From: Richard Temple
Sent: 16 January 2018 11:49
To: 'Ivan Salter'
Subject: RE: AW/350/17/CLP 36 Gossamer Lane, Aldwick

From: Richard Temple <Richard.Temple@arun.gov.uk>
Sent: 22 December 2017 12:52
To: 'ajsalterandson@hotmail.com'
Subject: AW/350/17/CLP 36 Gossamer Lane, Aldwick

C				
B				
A				
Client Mr & Mrs Cook				
Address 36 Gossamer Lane : Bognor				
Drawing PROPOSED ALTERATIONS			No. 7617:1	
Scale 1:50 1:100 1:500 1:1250		Drawn B		Date Oct 17

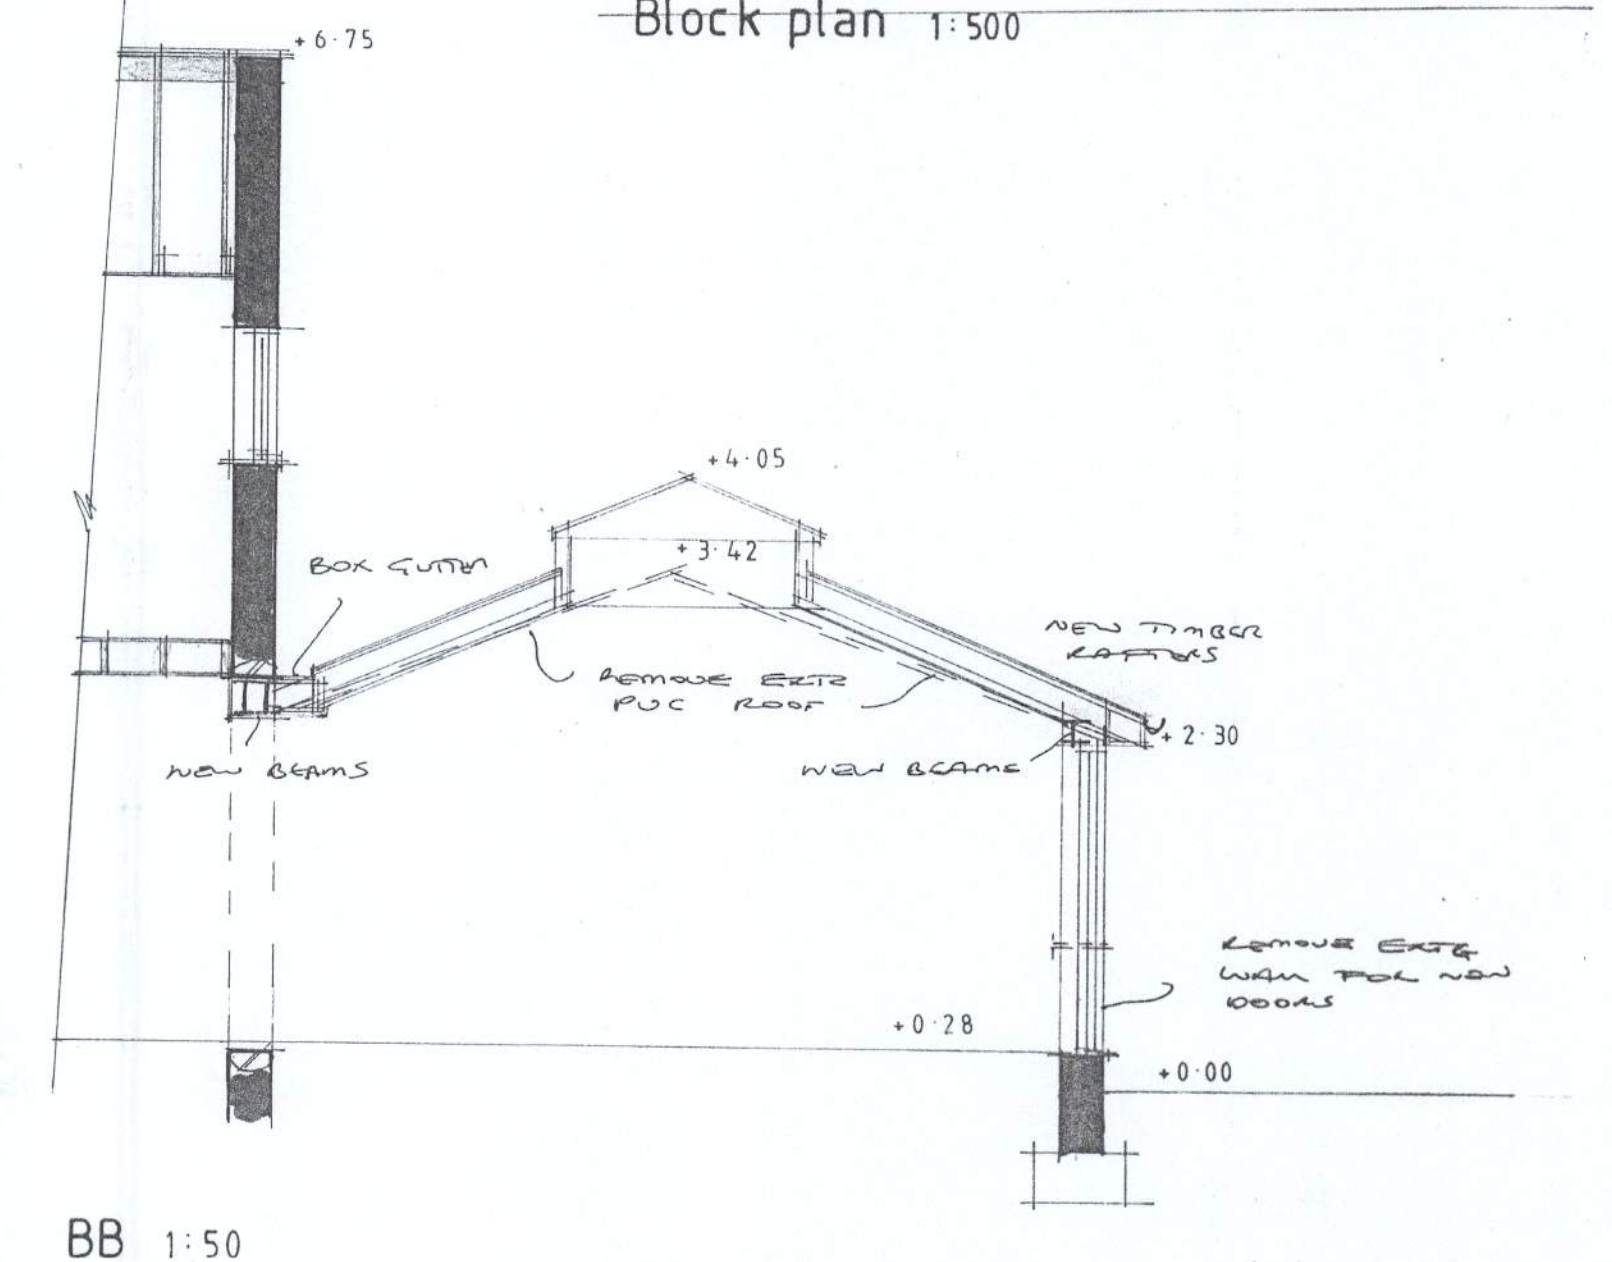
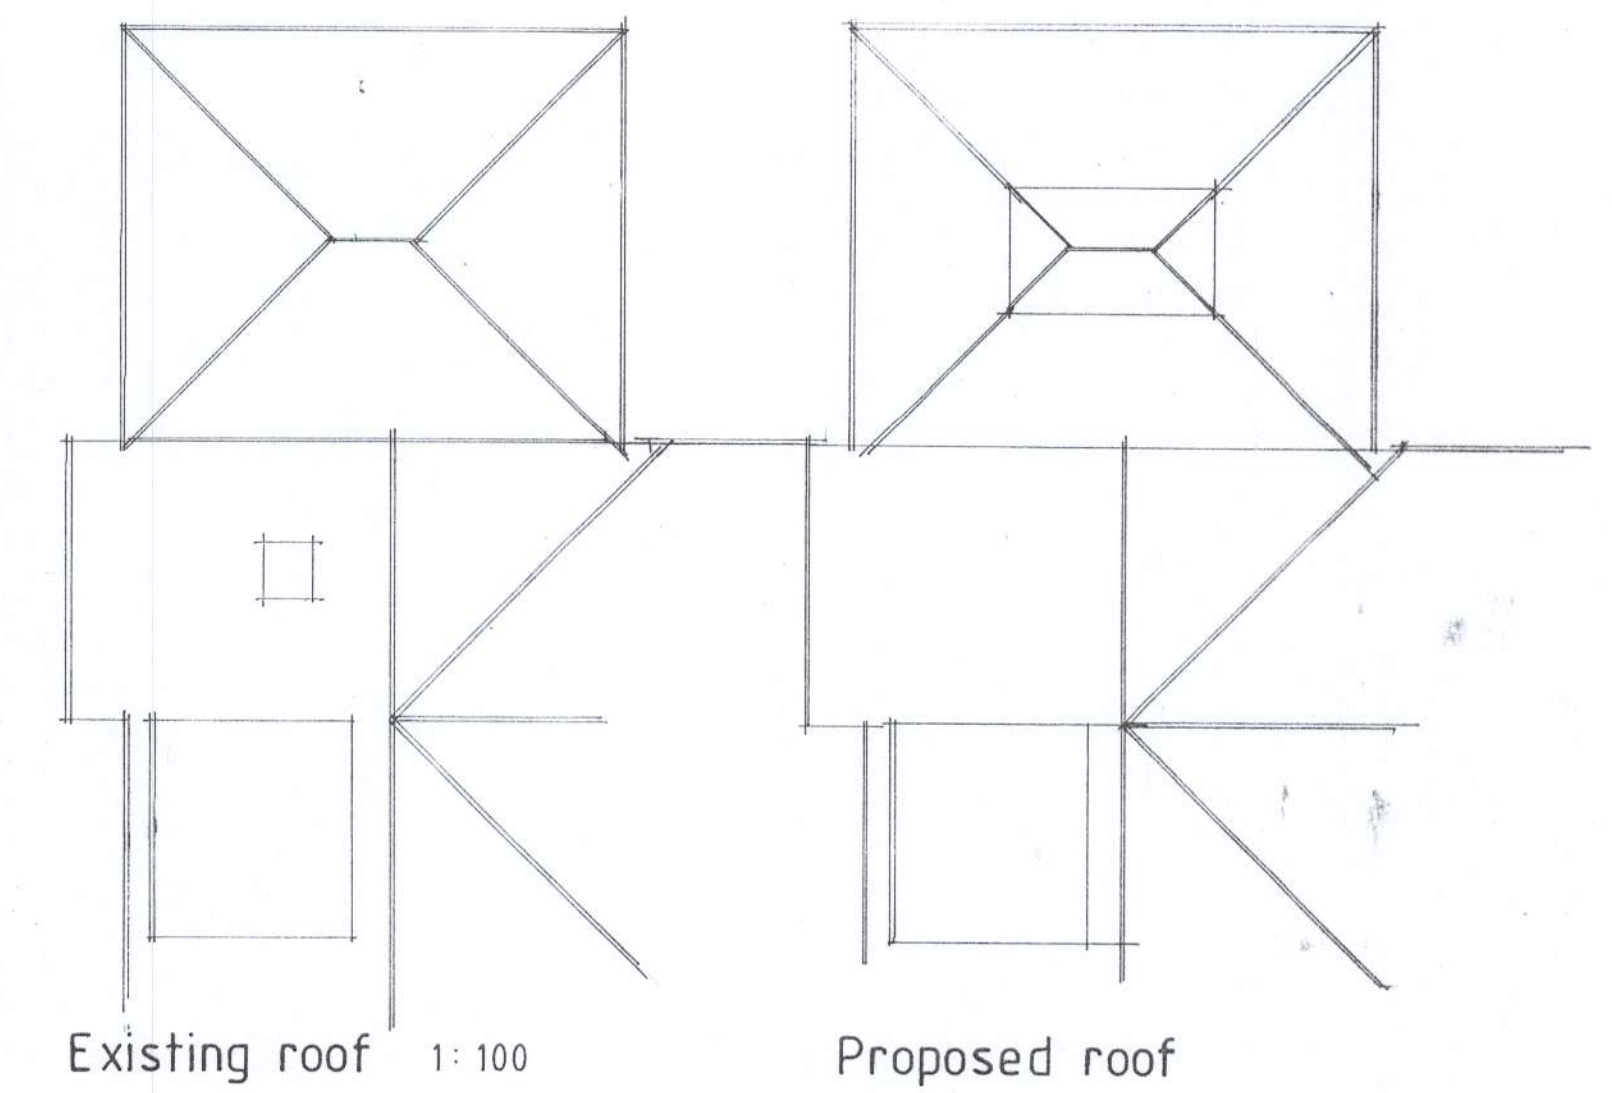
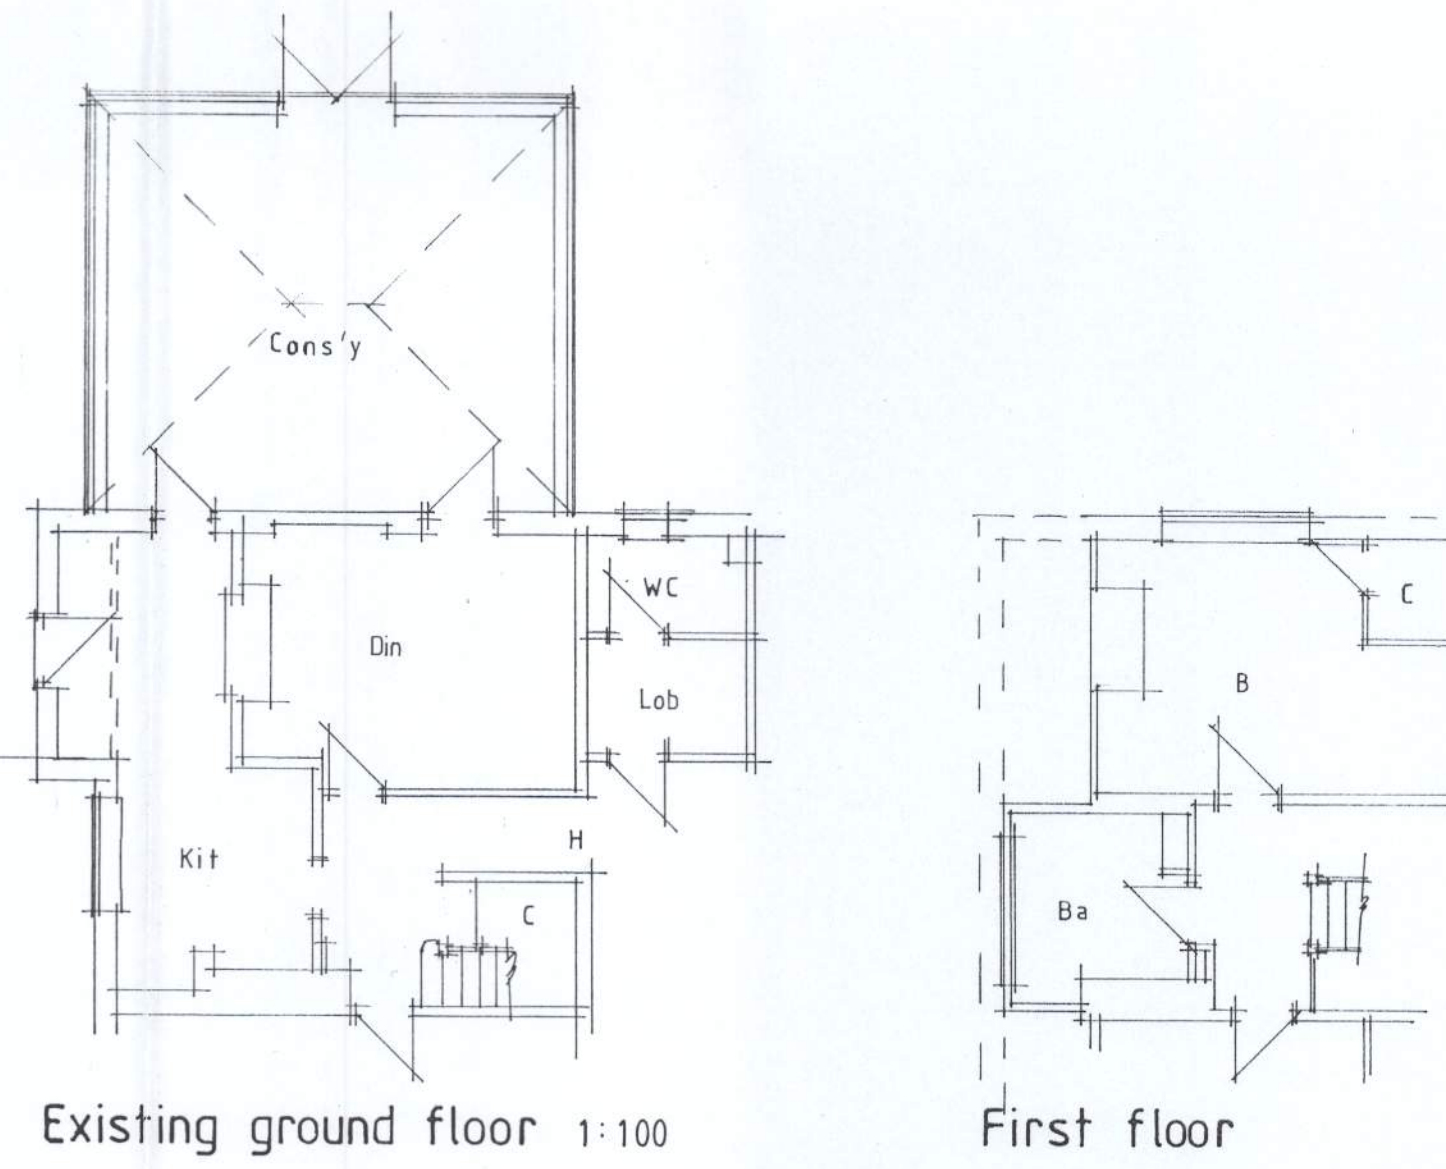
Although it appears clear on the application form, how is this to be constructed? Is the current extension to be demolished entirely and replaced by the new one or is the roof and top glazed parts (UPVC sections) of the extension to be removed and bottom part of wall retained and built up to create the new wall and roof? If the latter is the case then we may be able to recommend approval for the certificate.

Apologies for earlier email at first look at the plans it appeared a whole new extension was being proposed at over 5m deep.

I am unable to approve the application as under this CLP route extensions can only be 4m deep on detached houses.

I am able to recommend the application for approval on those grounds. I have consulted with my Team Leader who would be responsible for signing off the application.

Thanks for getting back to me. The proposal is to remove the windows and roof from the conservatory retaining the existing walls, then build up the walls where required, with windows where indicated, and provide new roof.
